**Application no: 21/02376/DISC**

**Location:** E P Barrus Ltd, Launton Road, Bicester, OX26 4UR

## **Transport Development Control**

Vehicle Specification

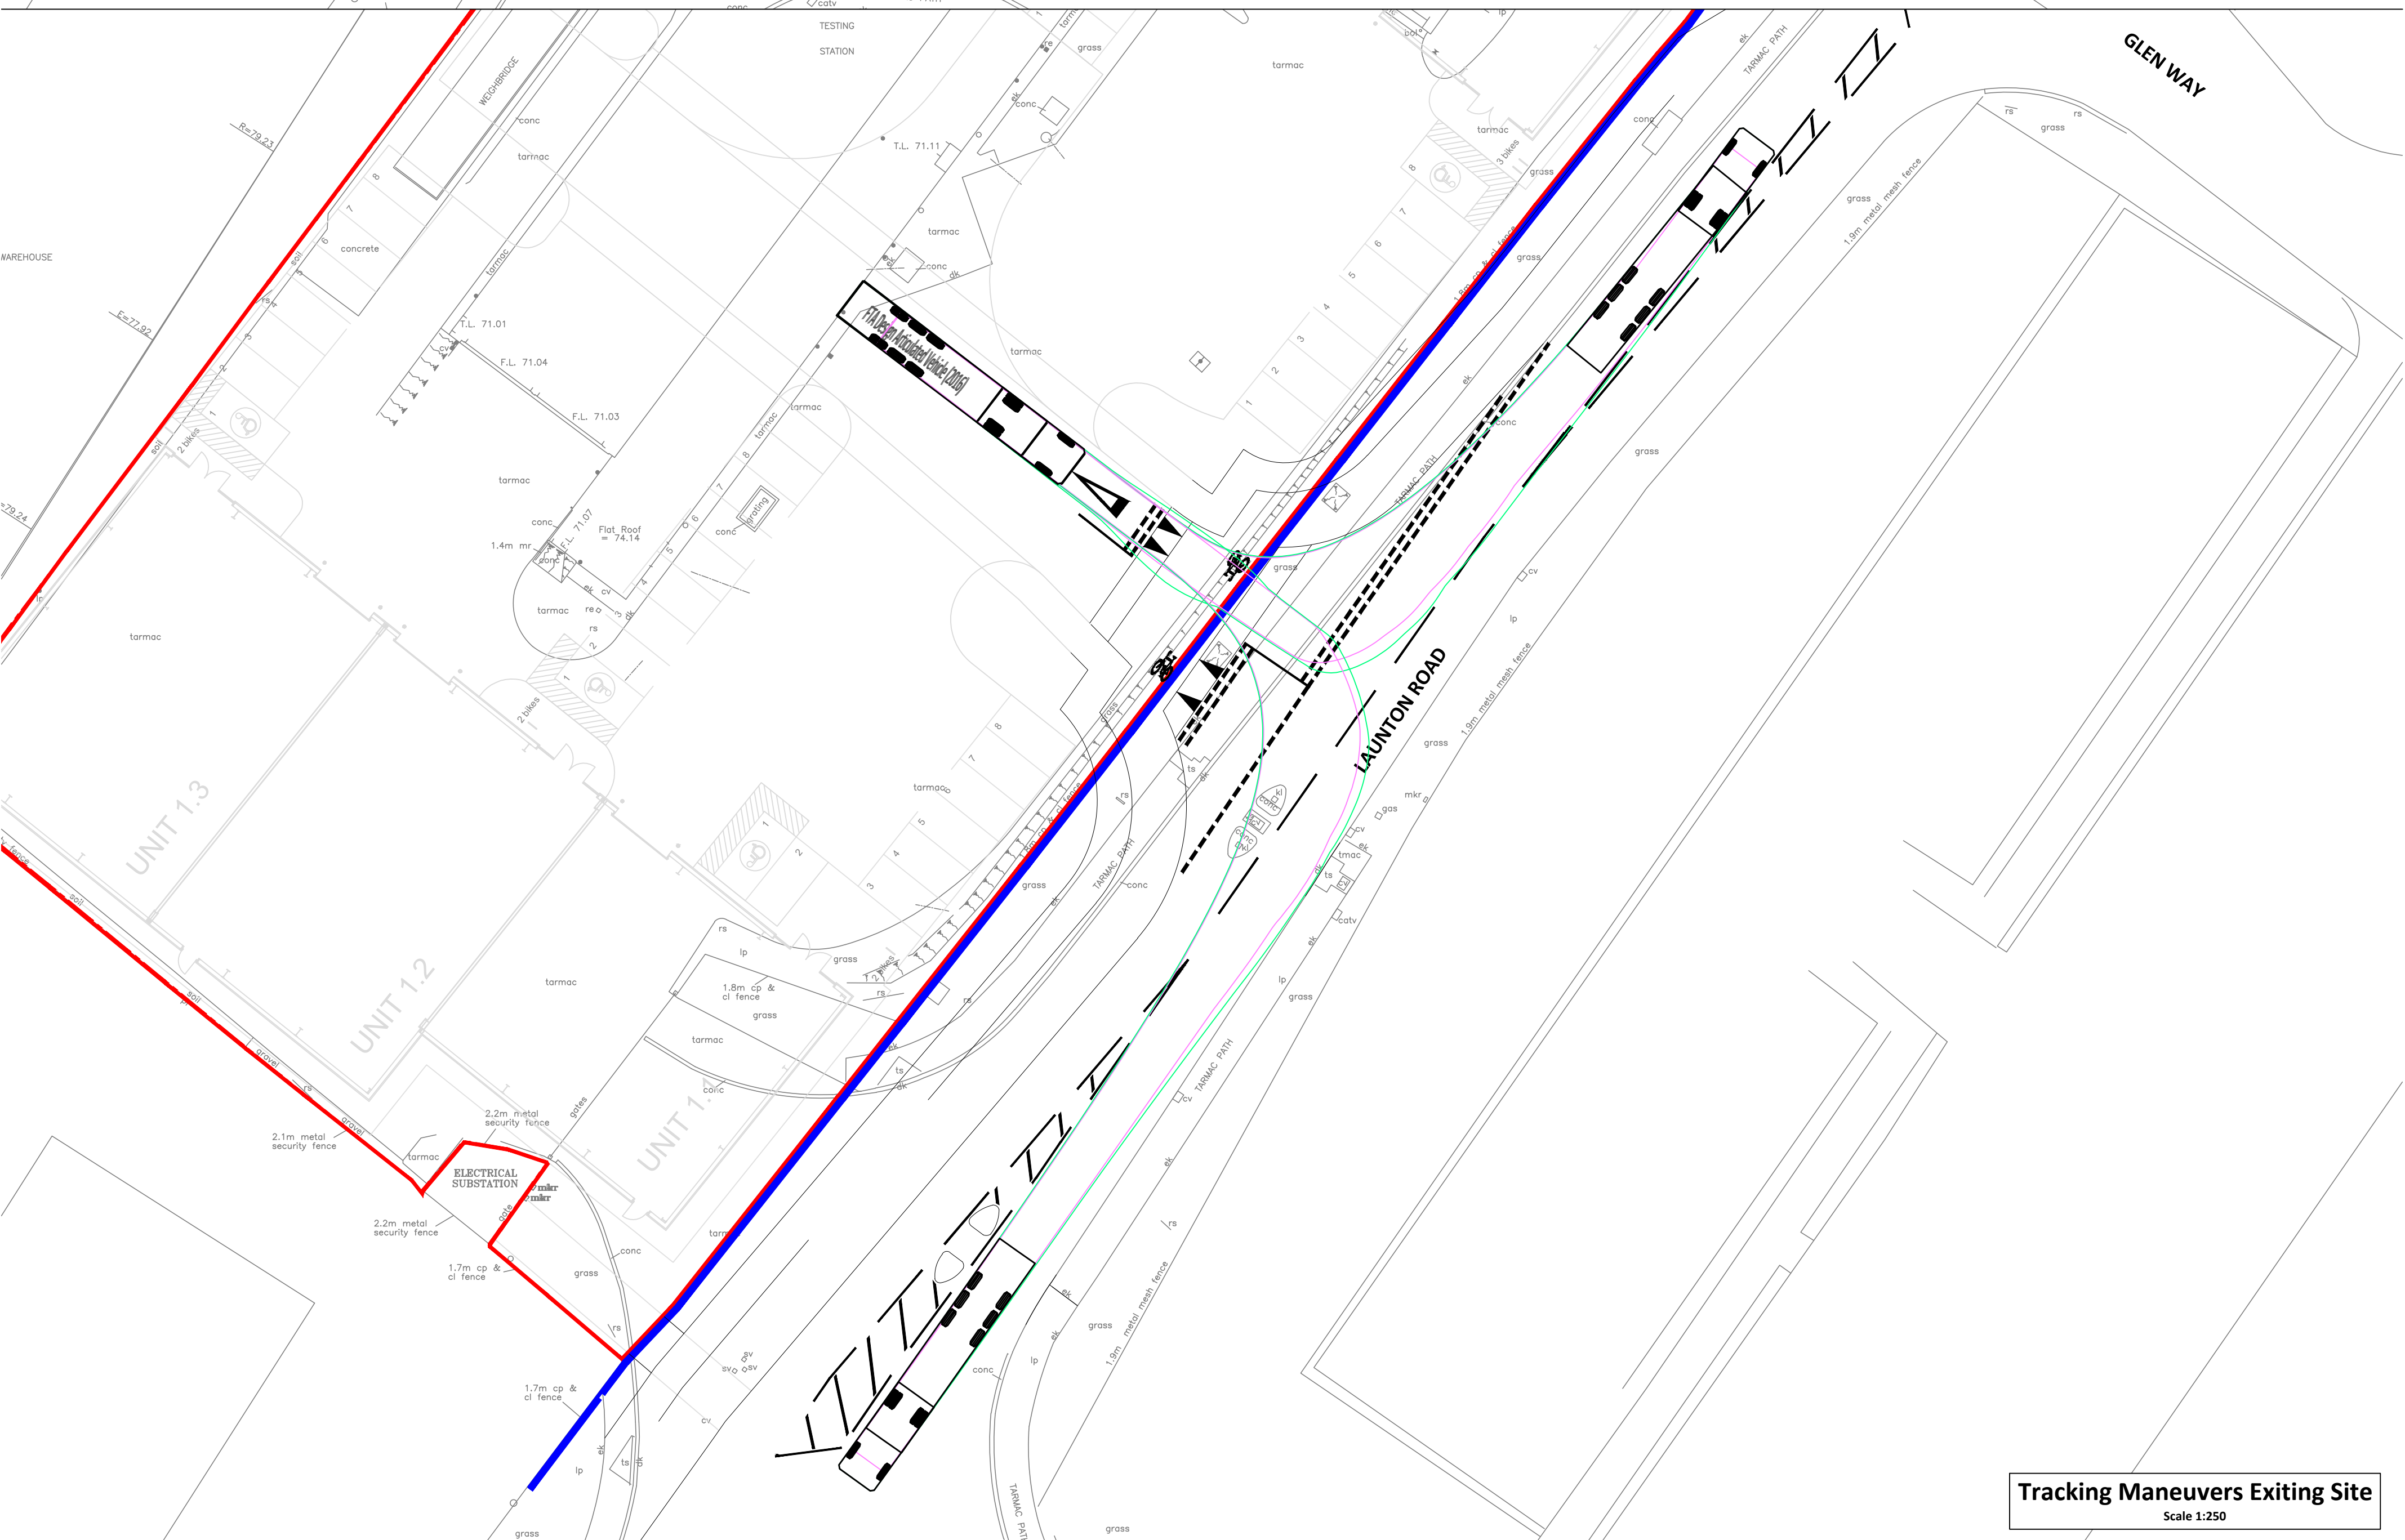
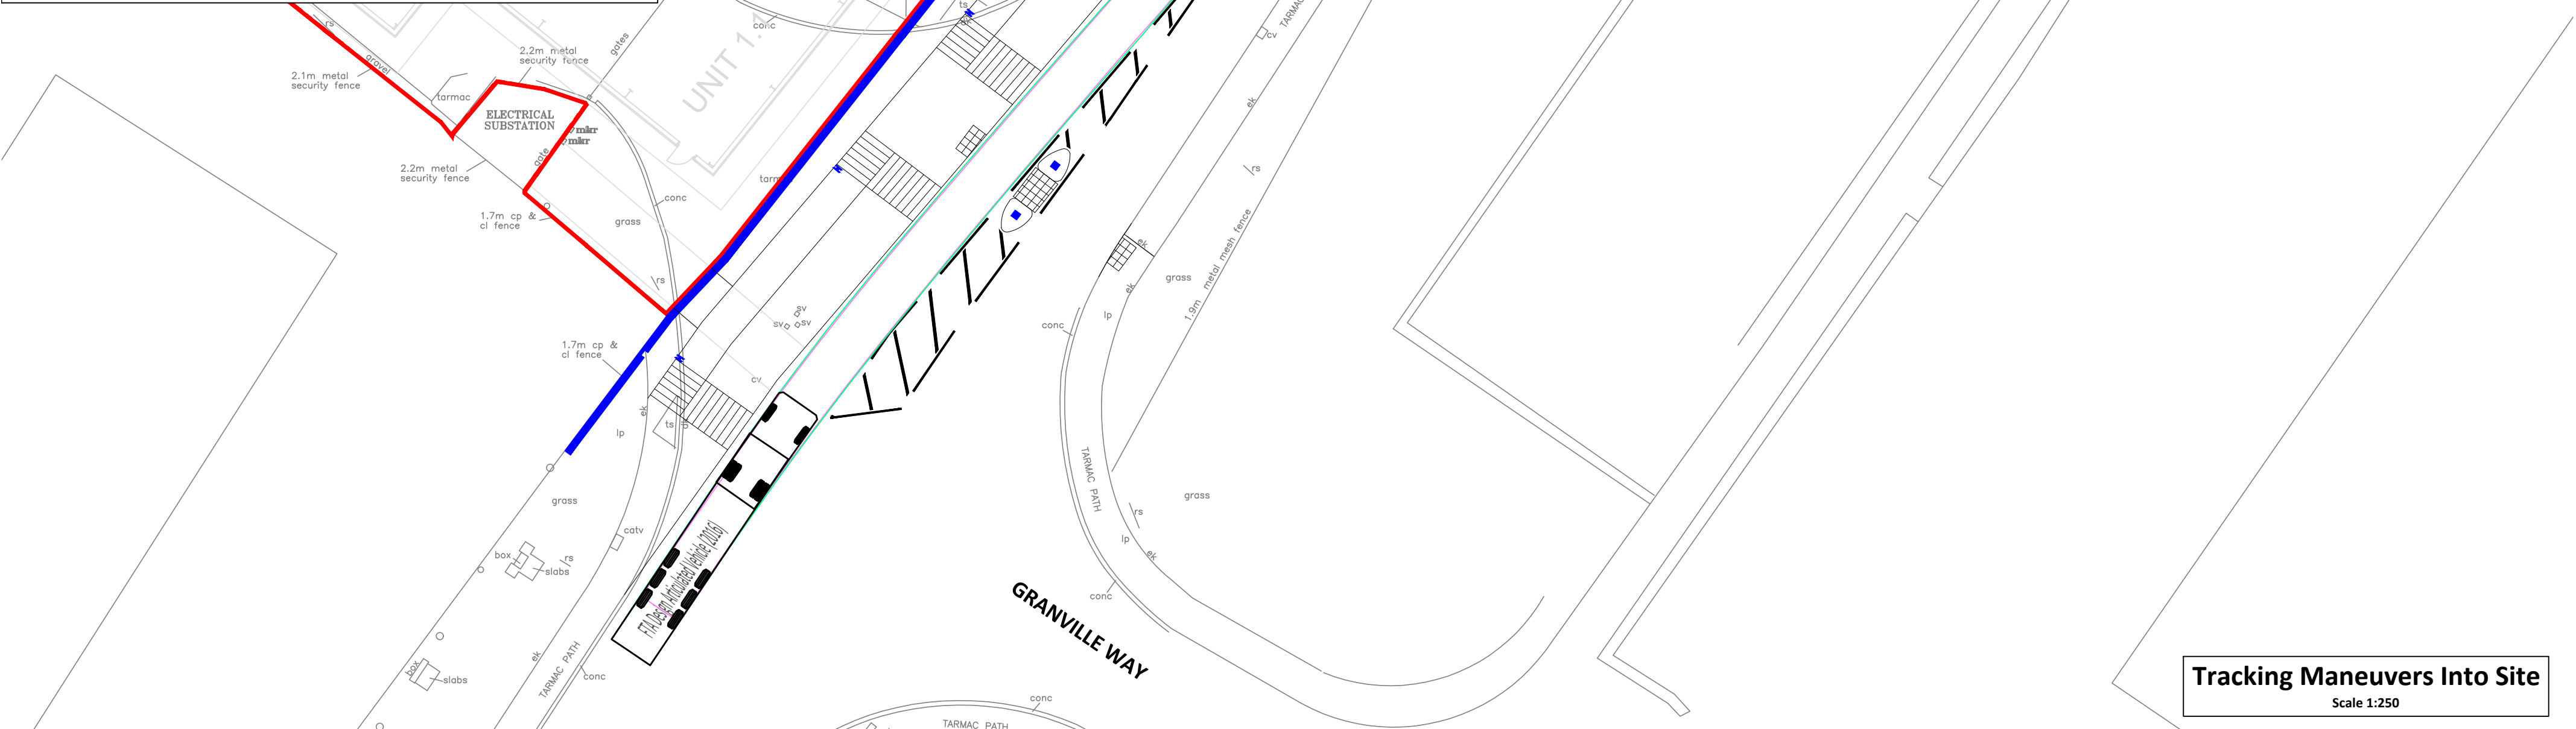
Condition 5 - The submitted tracking diagrams show that a vehicle can enter and exit the site safely in a forward gear. They do not demonstrate that a vehicle can safely turn within the site, to exit in a forward gear. The tracking diagrams also do not consider any alterations which may be required to make the site access LTN1/20 compliant. When a priority cycle crossing has been implemented, tracking should be carried out to demonstrate that an articulated vehicle can enter and exit the site in a forward gear.
